SUBJECT: **BRES2407-0066**
BUILDING RESIDENTIAL

Here are the results of all Inspections located at **1604 BRICK MILL RD:**

Inspection Type: ROUGH IN
Scheduled Date/Time: 10/9/2024
Completed Date/Time: 10/9/2024
Inspector: Steven Gazlay
Result: DISAPPROVED

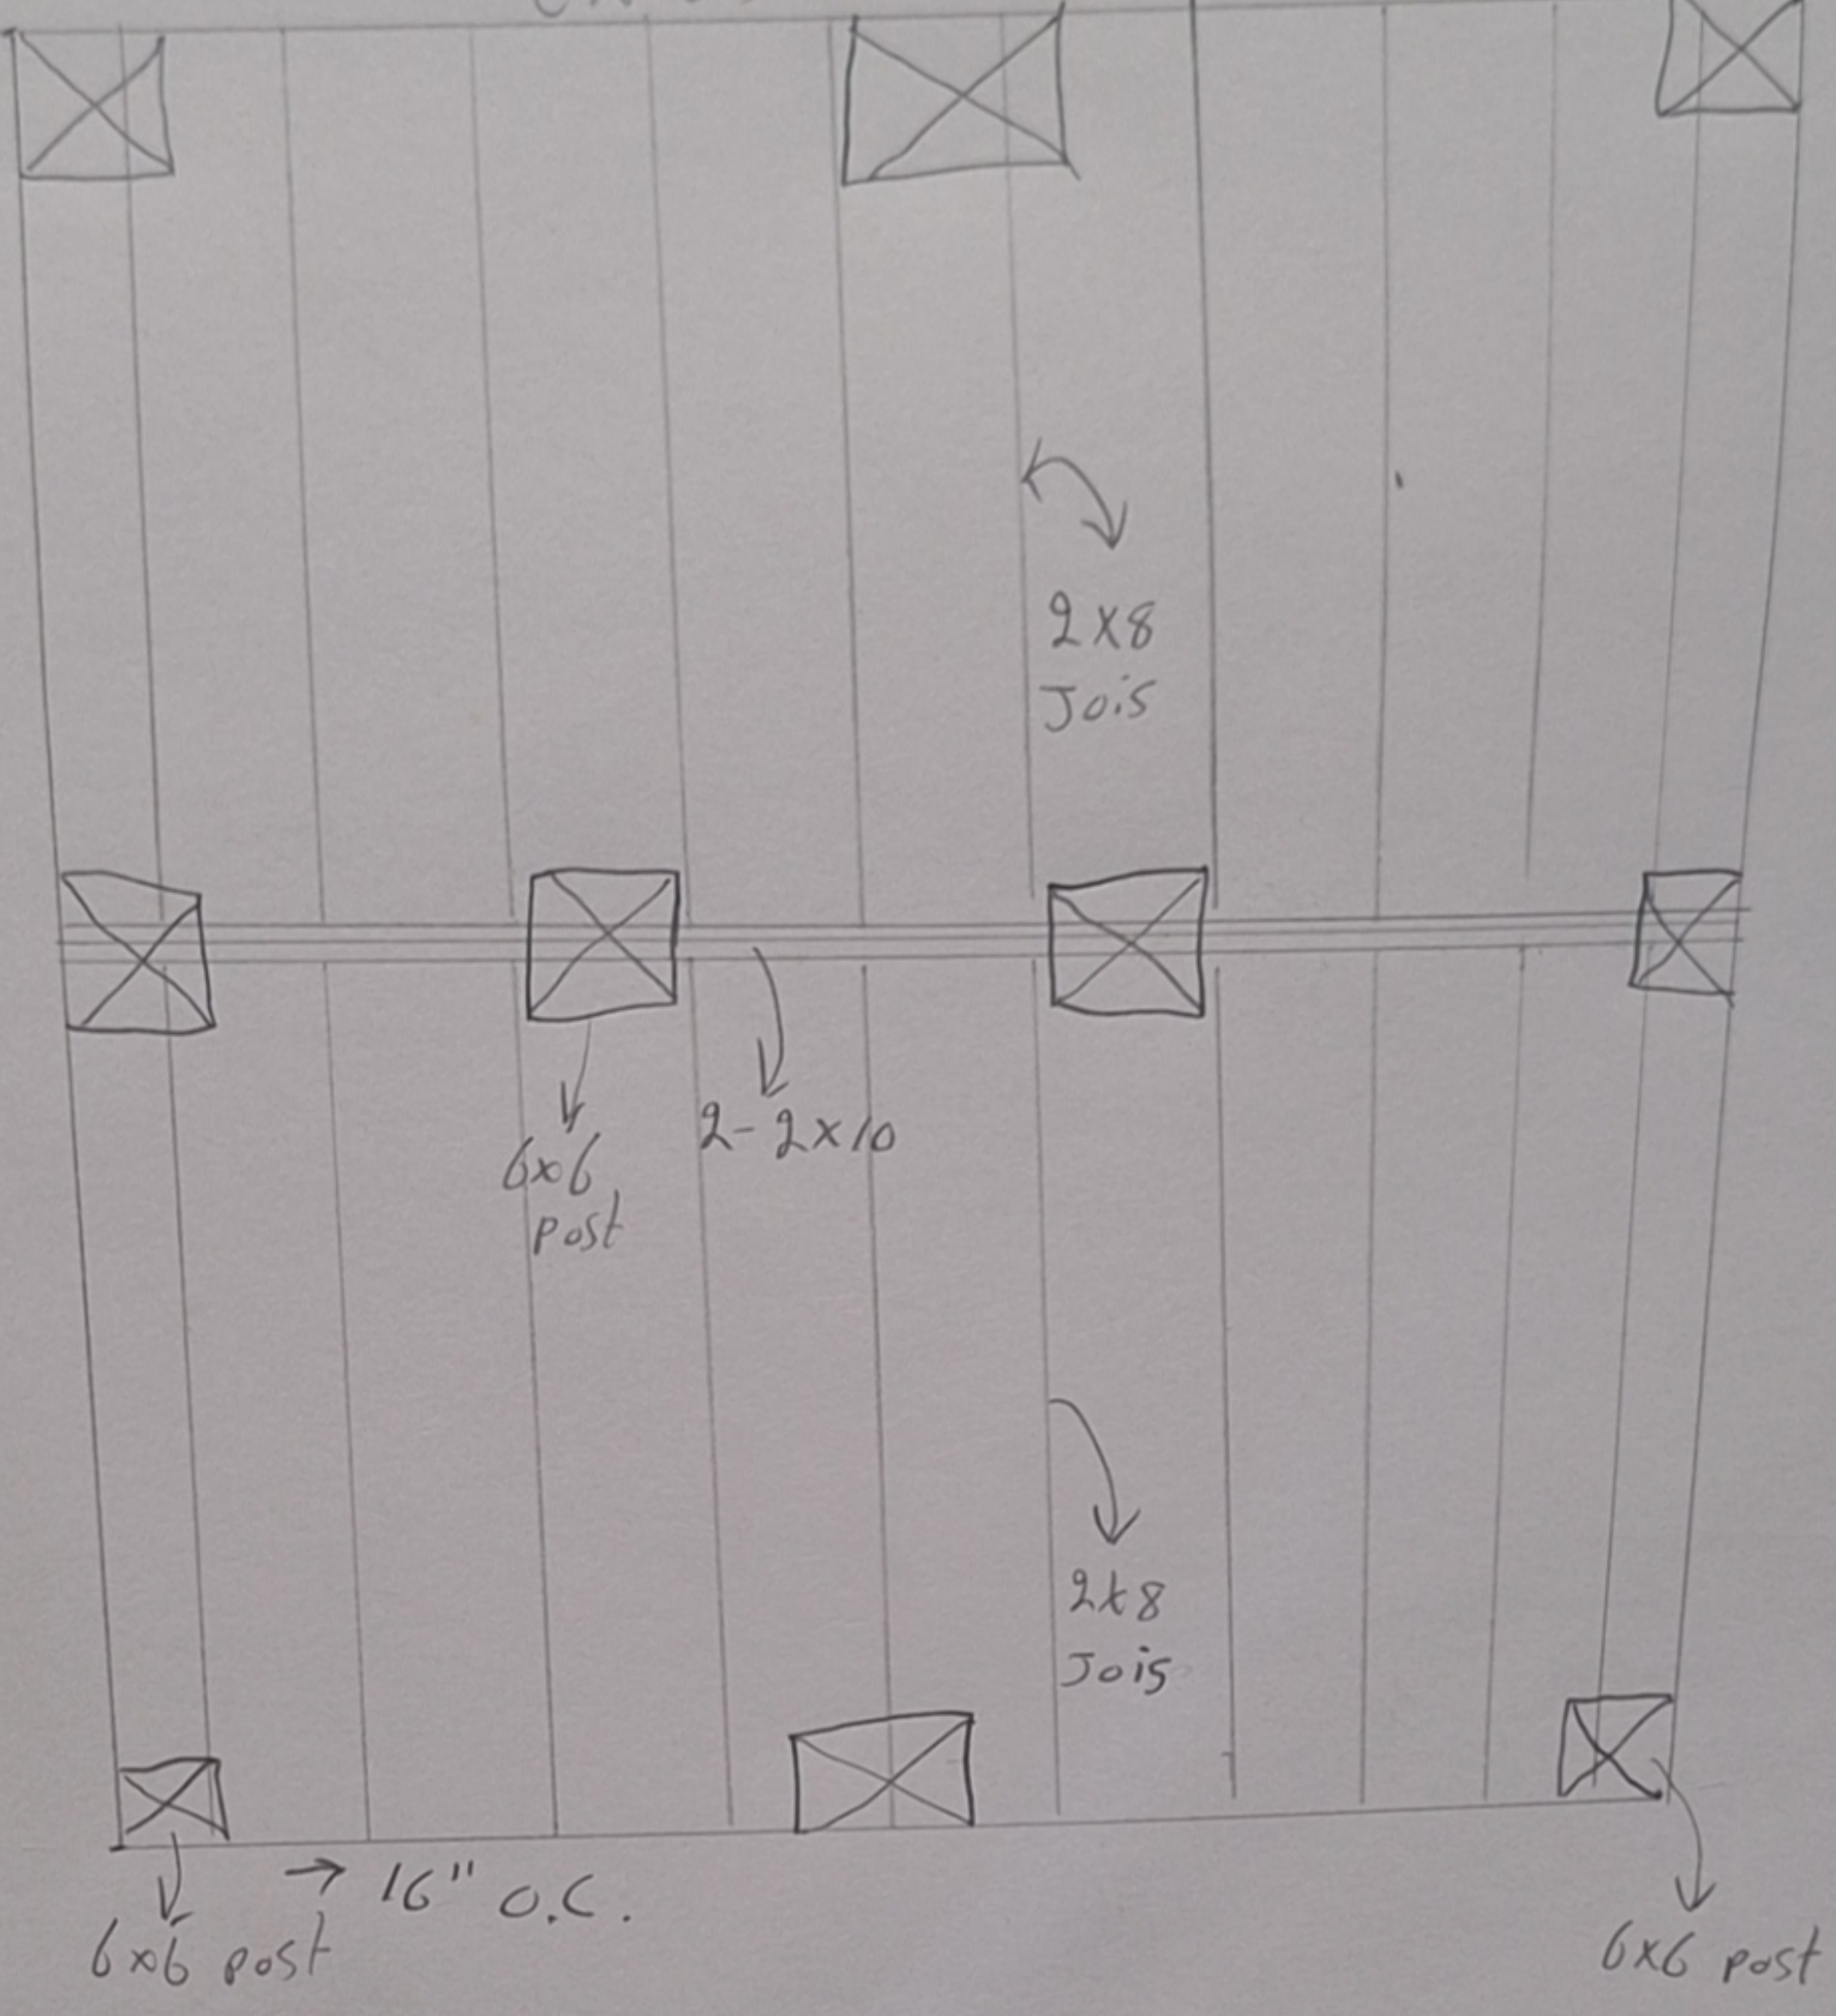
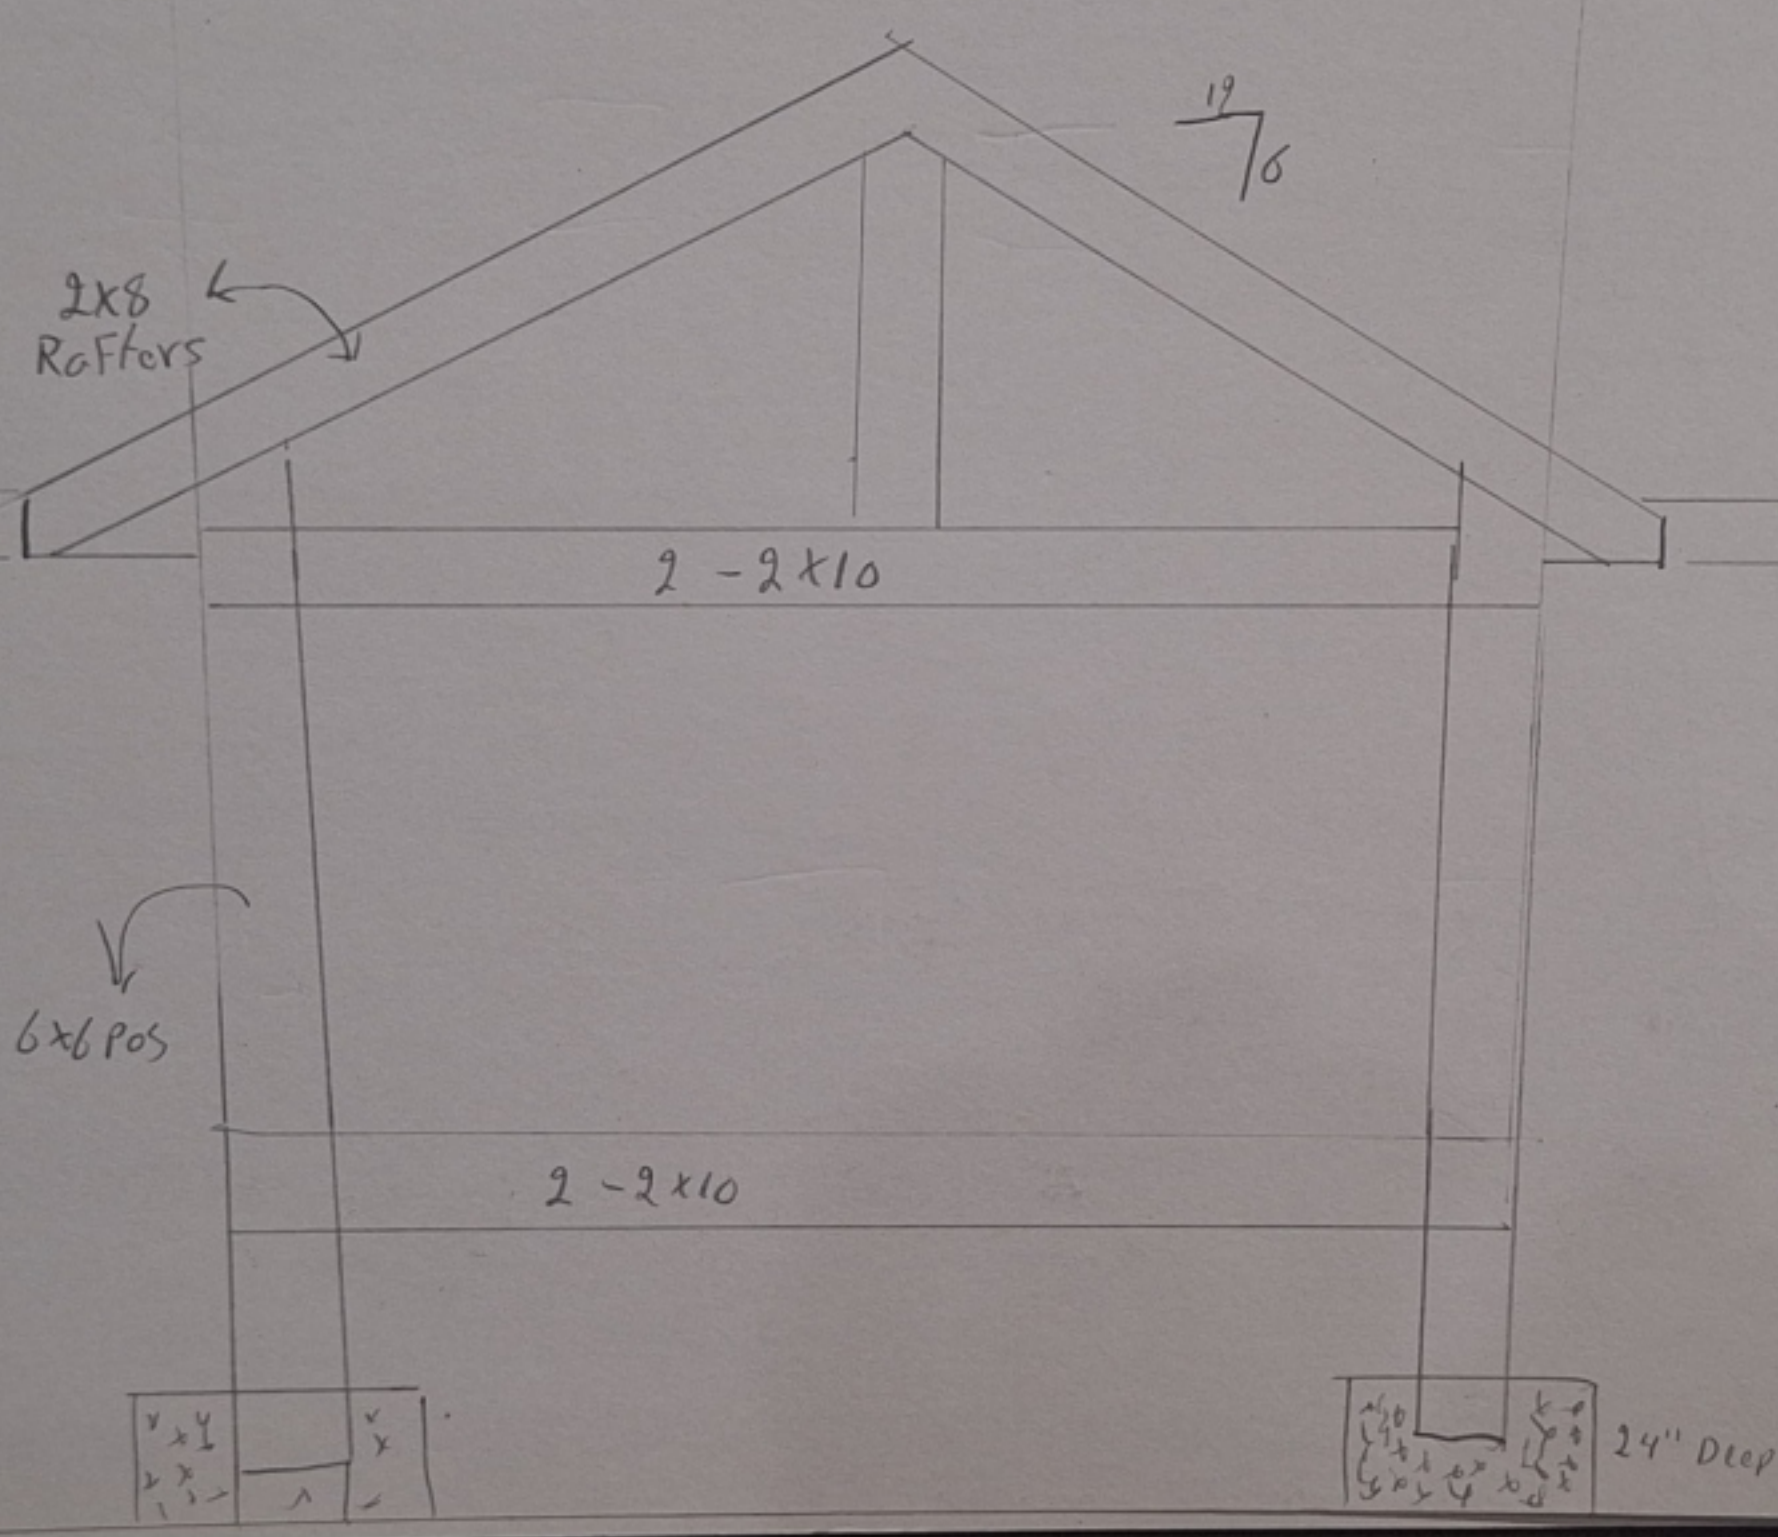
Footing inspection never approved, footings not constructed to code. Provide engineering for no rafter ties and ridge not sized as beam. Need code compliant method to attach headers and girders to posts. Remove osb to allow inspection of framing onto house.
